Ribble Valley Borough Council  
Housing & Development Control

Application no: **3/2023/0015**

Address: **Laneside House Settle Road Bolton by Bowland BD23 4SL**

Proposal: **Proposed new driveway access from Settle Road.**

1 Visibility Splays
1:500 @ A1

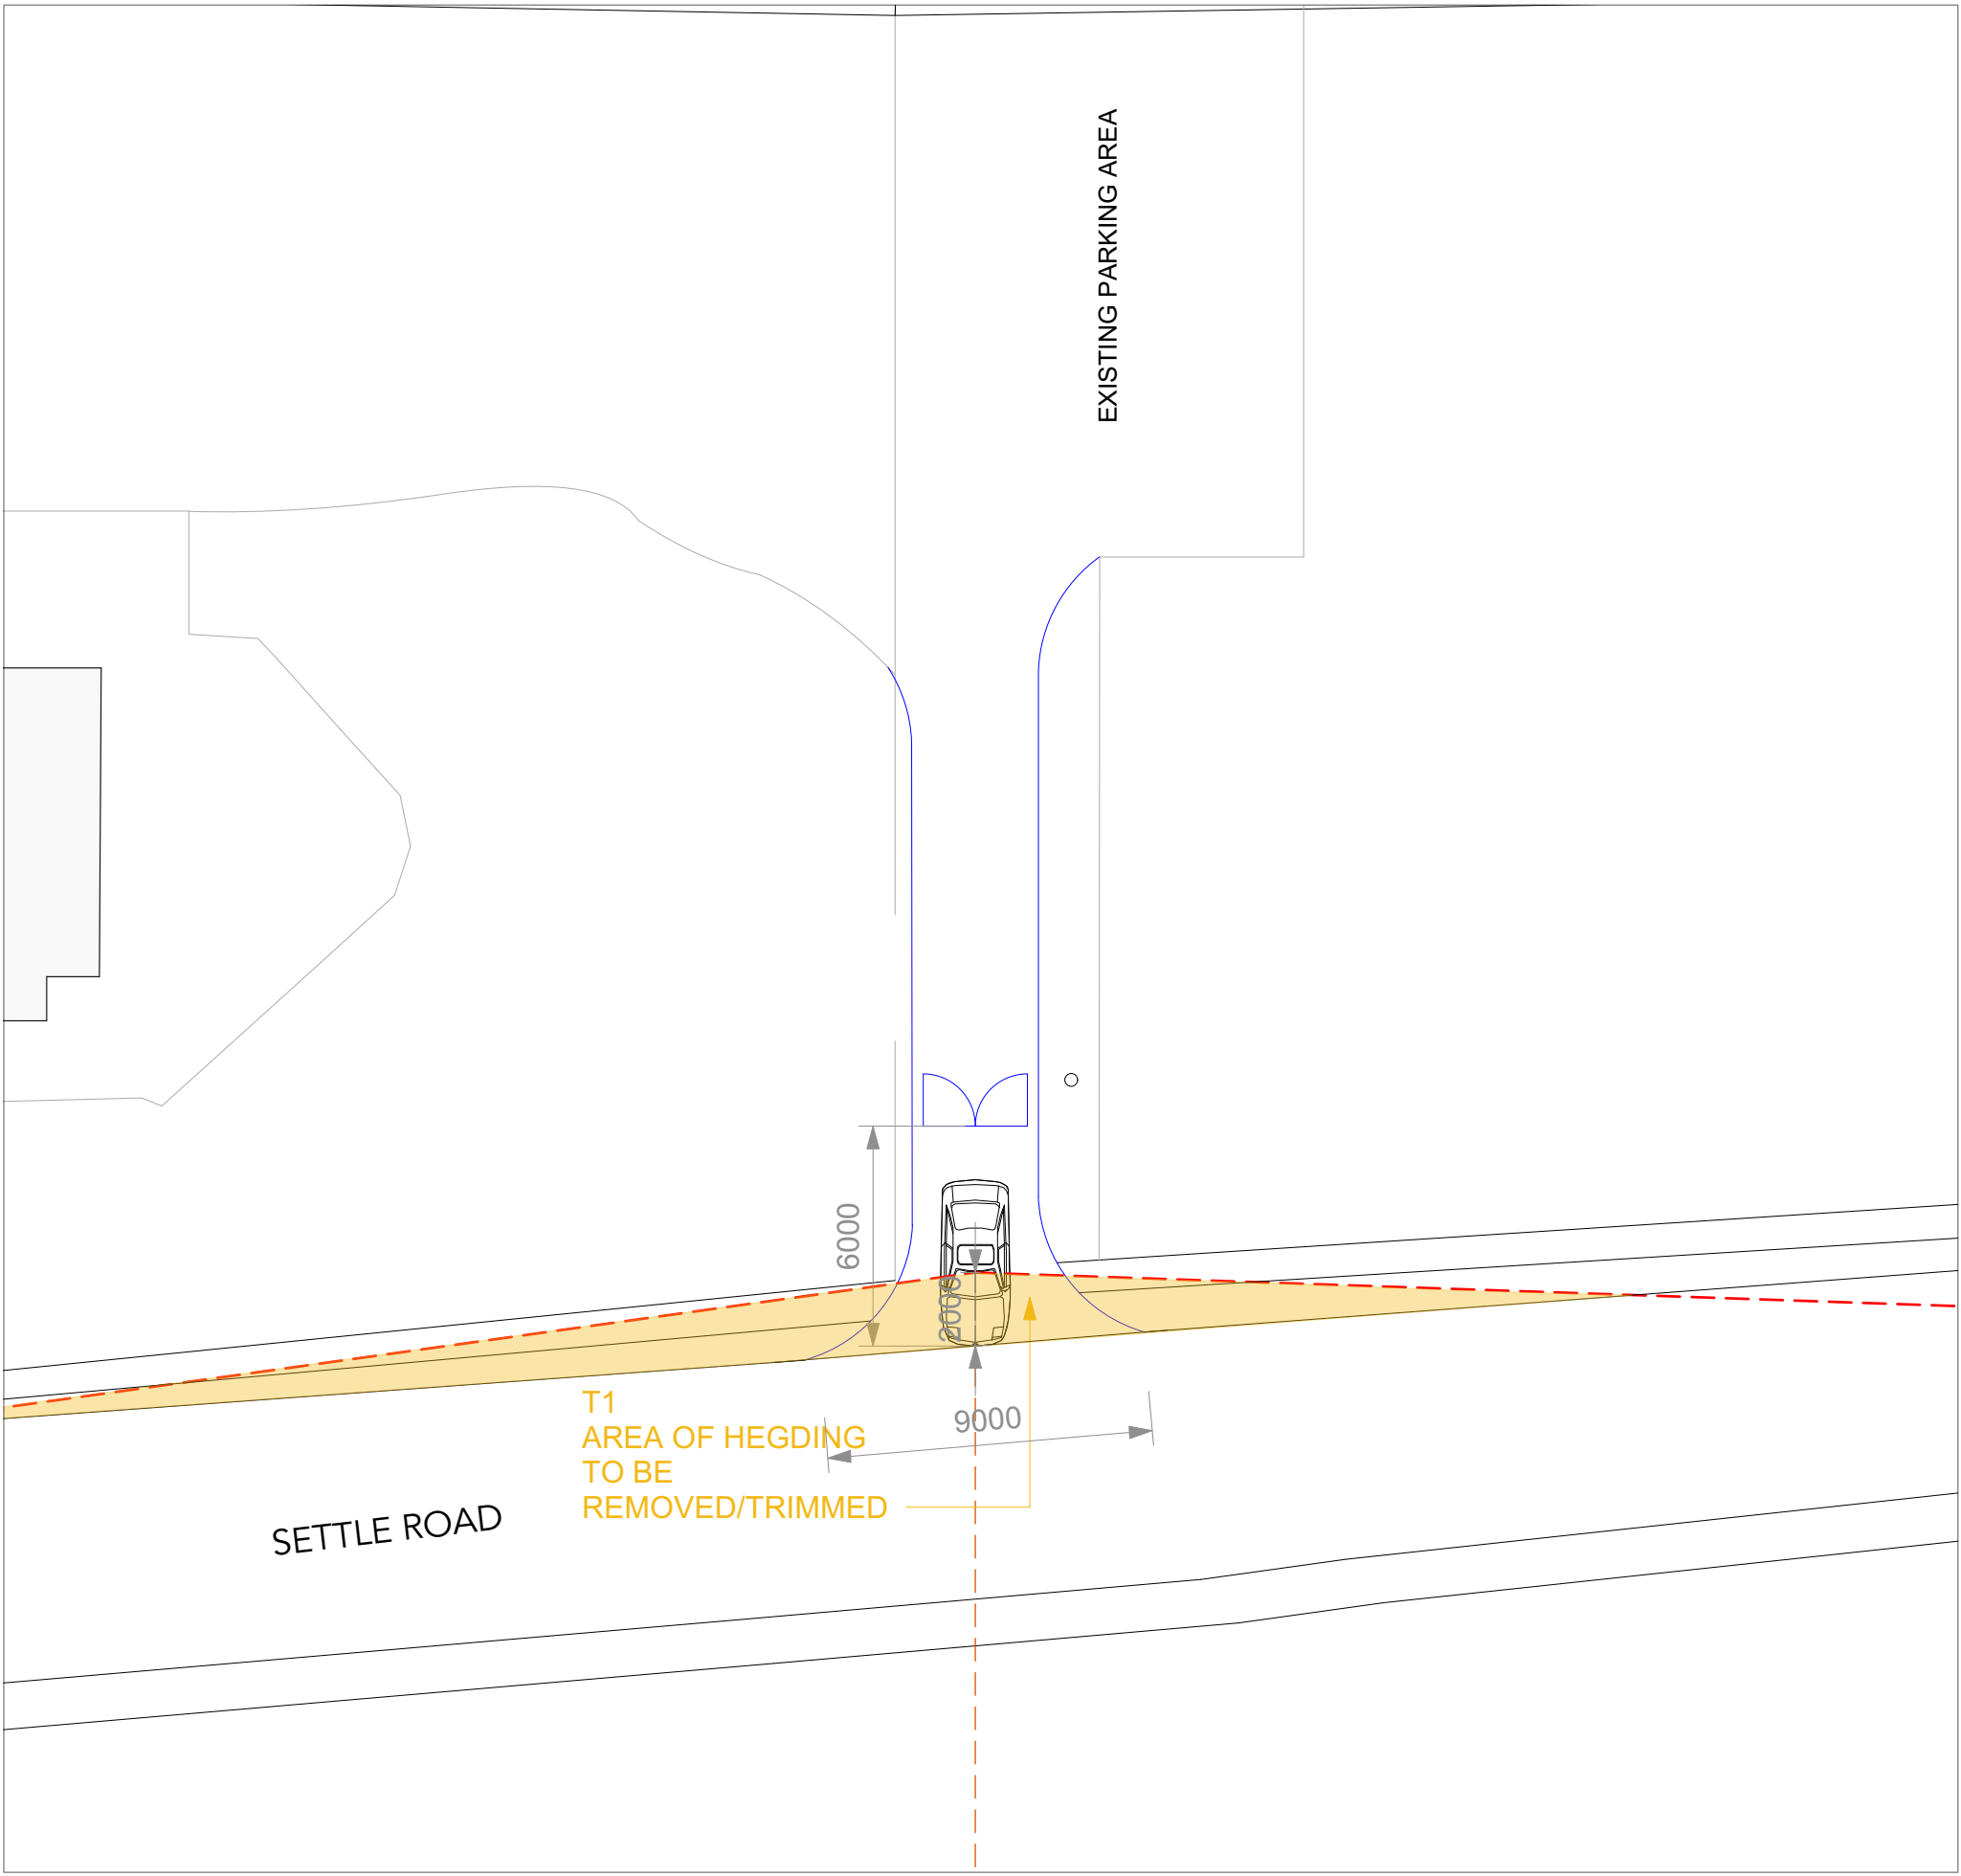
The LHA have reviewed drawing number LH-ND-003-A titled "Proposed New Access Settle Road C590" and are aware that the proposed new access is located approximately 45m north-east of the existing access which has already been stopped up.

The LHA have further reviewed drawing number LH-ND-003-A and are aware that the proposed access will be 9m wide and will then reduce to approximately 3.5m wide, a distance of approximately 2.7m away from the adopted highway. This complies with the LHAs guidance when serving a single dwelling.

The traffic survey was conducted between 18<sup>th</sup>- 24<sup>th</sup> November 2020 and the survey found that the 85<sup>th</sup> percentile speeds were 43.5mph north eastbound and 44.7mph south westbound. This means that the site is required to provide visibility splays of 2m x 117m to the east and 2m x 123m to the west of the proposed access.

These visibility splays are shown on drawing number LH-ND-003-A titled "Proposed New Access Settle Road C590" and so the LHA have no objection to the proposal.

1. No part of the development hereby permitted shall be occupied until such time as the access arrangements shown on drawing number LH-ND-003-A titled "Proposed New Access Settle Road C590" have been implemented in full.

2. No part of the development hereby permitted shall be occupied until such time as vehicular visibility splays of 2 metres by 117 metres eastbound and 2 metres by 123 metres westbound have been provided at the site access. These shall thereafter be
